SSD 16_7894: CHAU CHAK WING MUSEUM UNIVERSITY OF SYDNEY, CAMPERDOWN CAMPUS

UNIVERSITY OF SYDNEY RESPONSE TO SUBMISSIONS – SUPPLEMENTARY INFORMATION

22 JANUARY 2018

1. UNIVERSITY OF SYDNEY RESPONSE TO GOVERNMENT ARCHITECT'S OFFICE RECEIVED 17 JANUARY 2018

Drawing Title SITE PLAN	Project Number 15037	Documentation Stage DEVELOPMENT APPLICATION
Drawing Number JPW-DA-A-0500	Revision 02

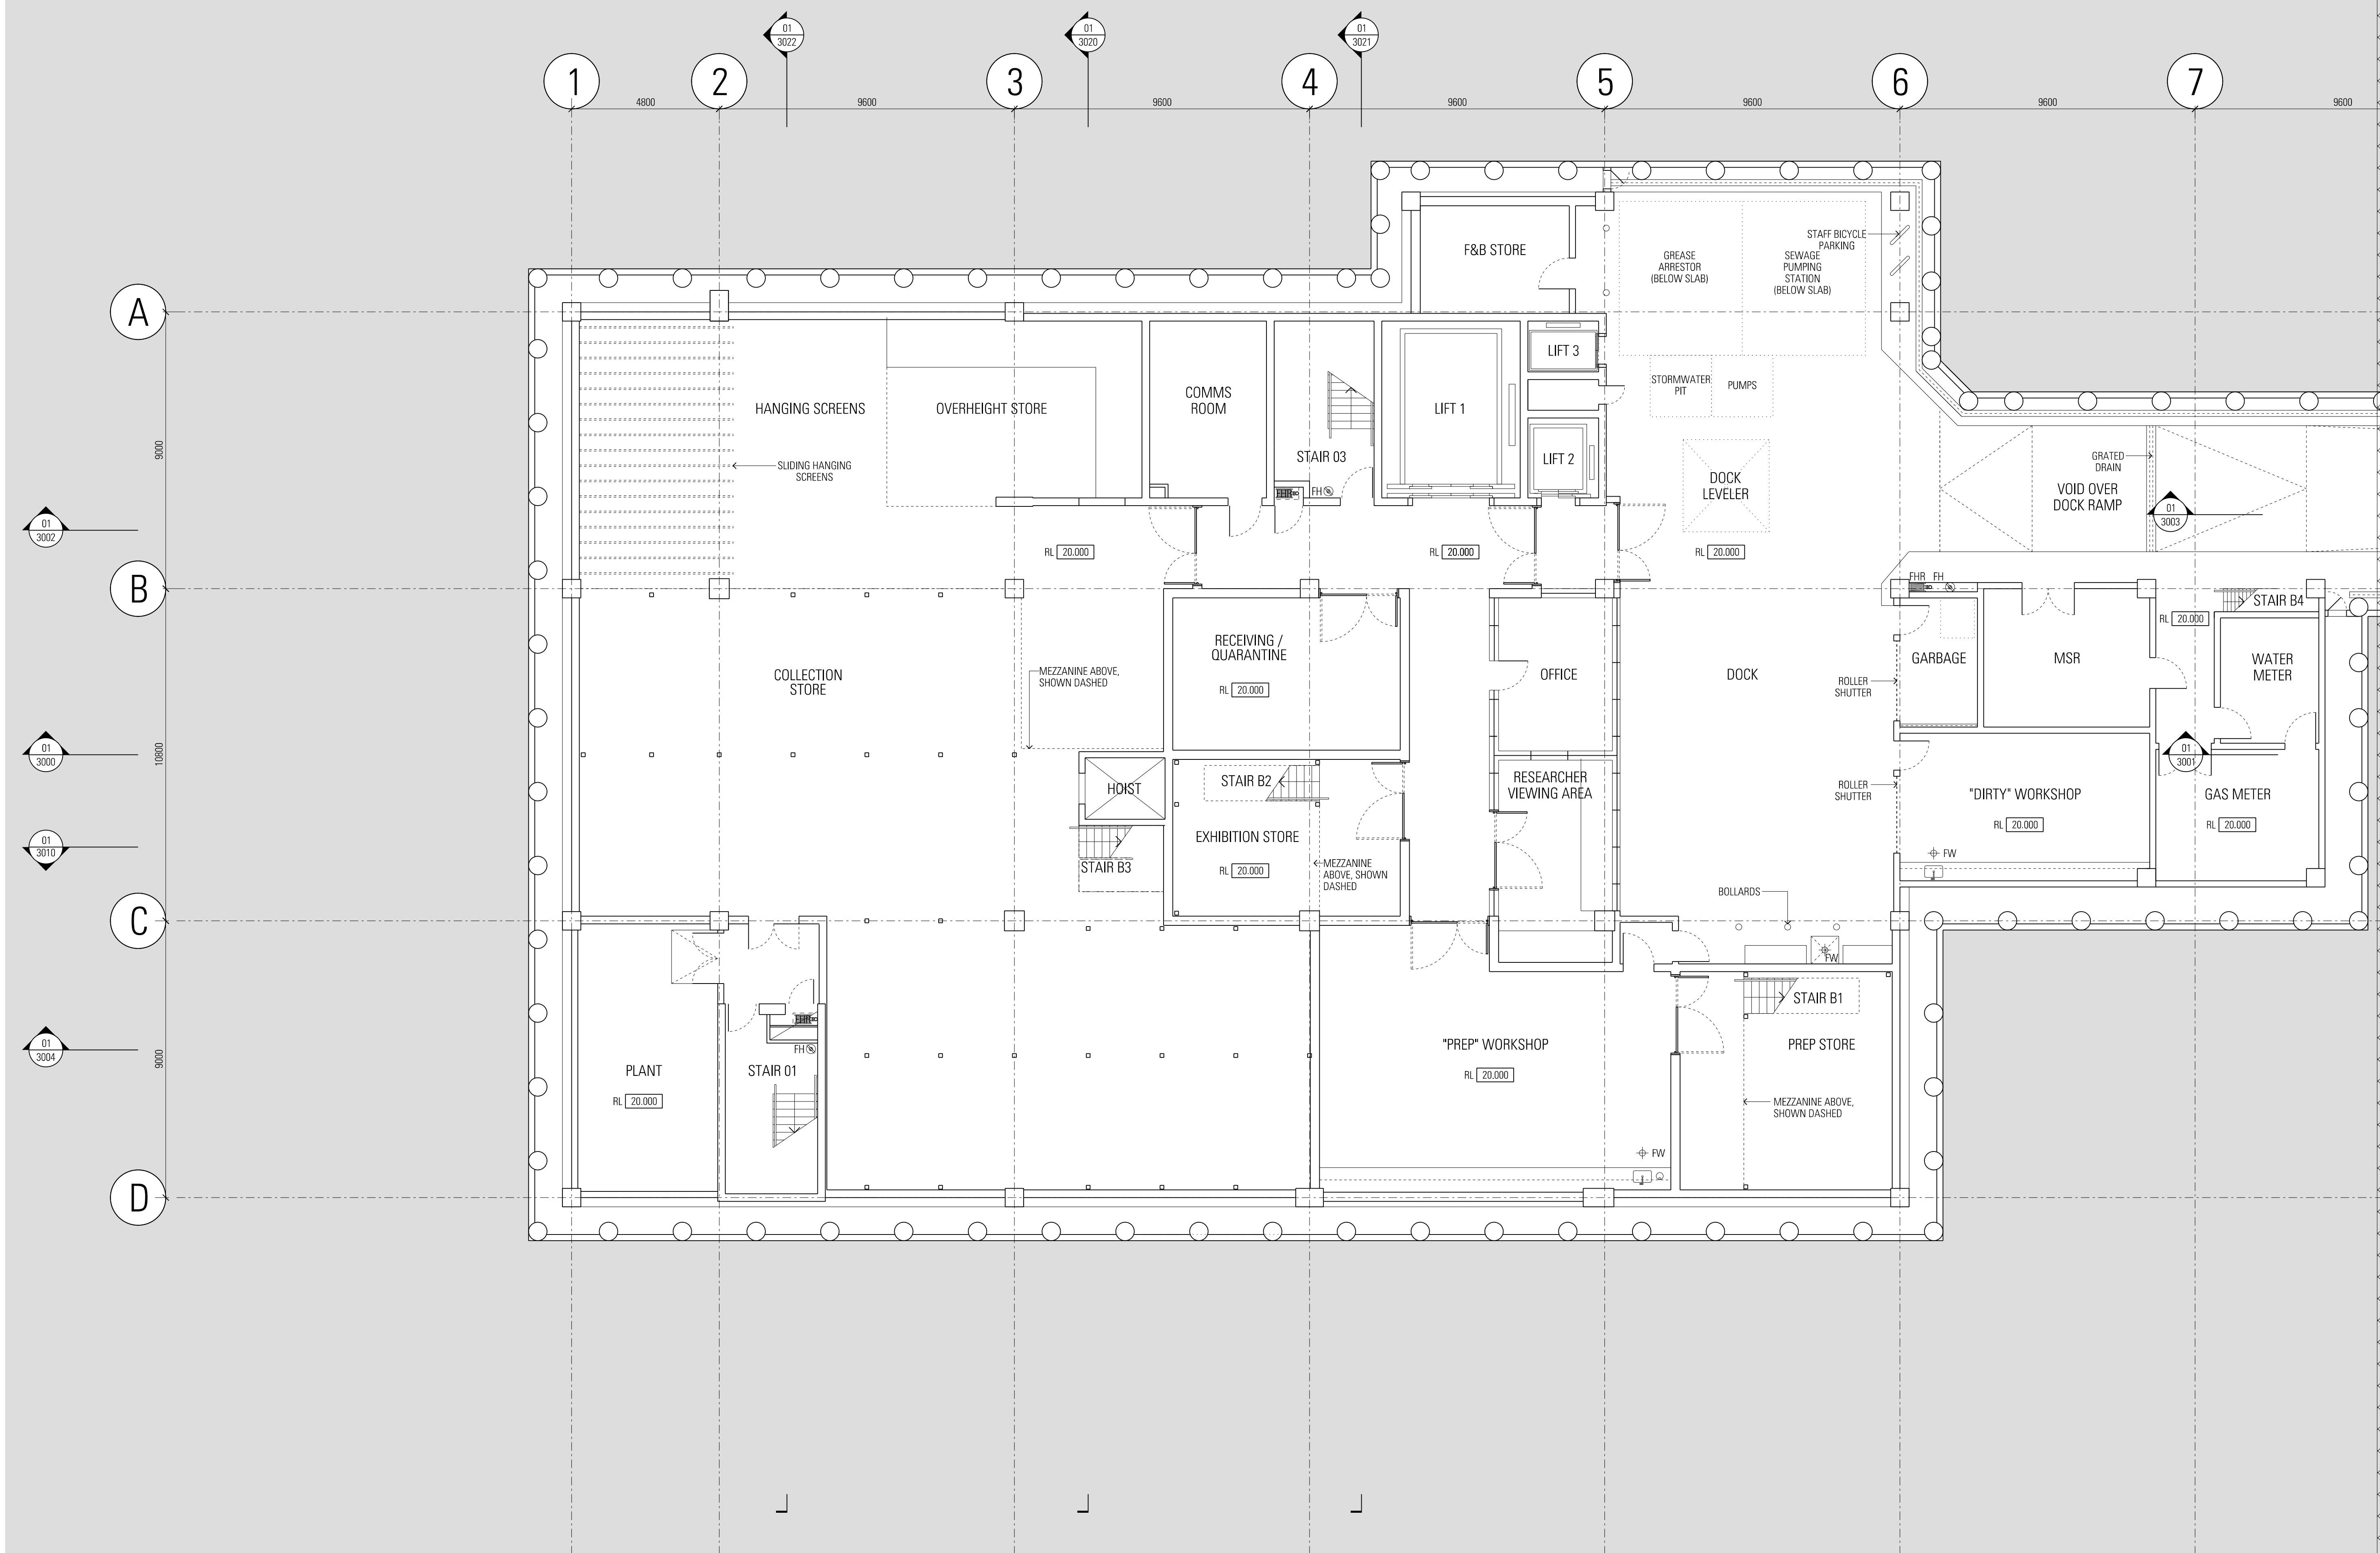
OGA KEY ISSUE	UNIVERSITY PROJECT RESPONSE
<p>2. The summary states that an additional 'gathering space' has been provided to the northwest, however, developed drawings to demonstrate this have not been provided.</p>	<p>USyd: The University highlights the revised Ground Plan L-0500 version 2 which was submitted with our Response to Submissions document. The Plan (refer to page 4) highlights the new 'Gathering Space' at the northwest campus domain outside the building and the comparison with the original SSD Plan Revision 1 illustrates the extent of the new area. This space is designed and located specifically adjoining the intersection of the University lawn and Museum entrance in consideration of the University's <i>Wingara Mura-Bunga Barrabugu Strategy</i> and will provide an area for ceremonial activities and informal gatherings. The new gathering space is approximately 100m2.</p>
<p>3. The intent to provide open public space associated with the entry to the west and the northern façade and landscape is supported.</p>	<p>USyd: Noted</p>
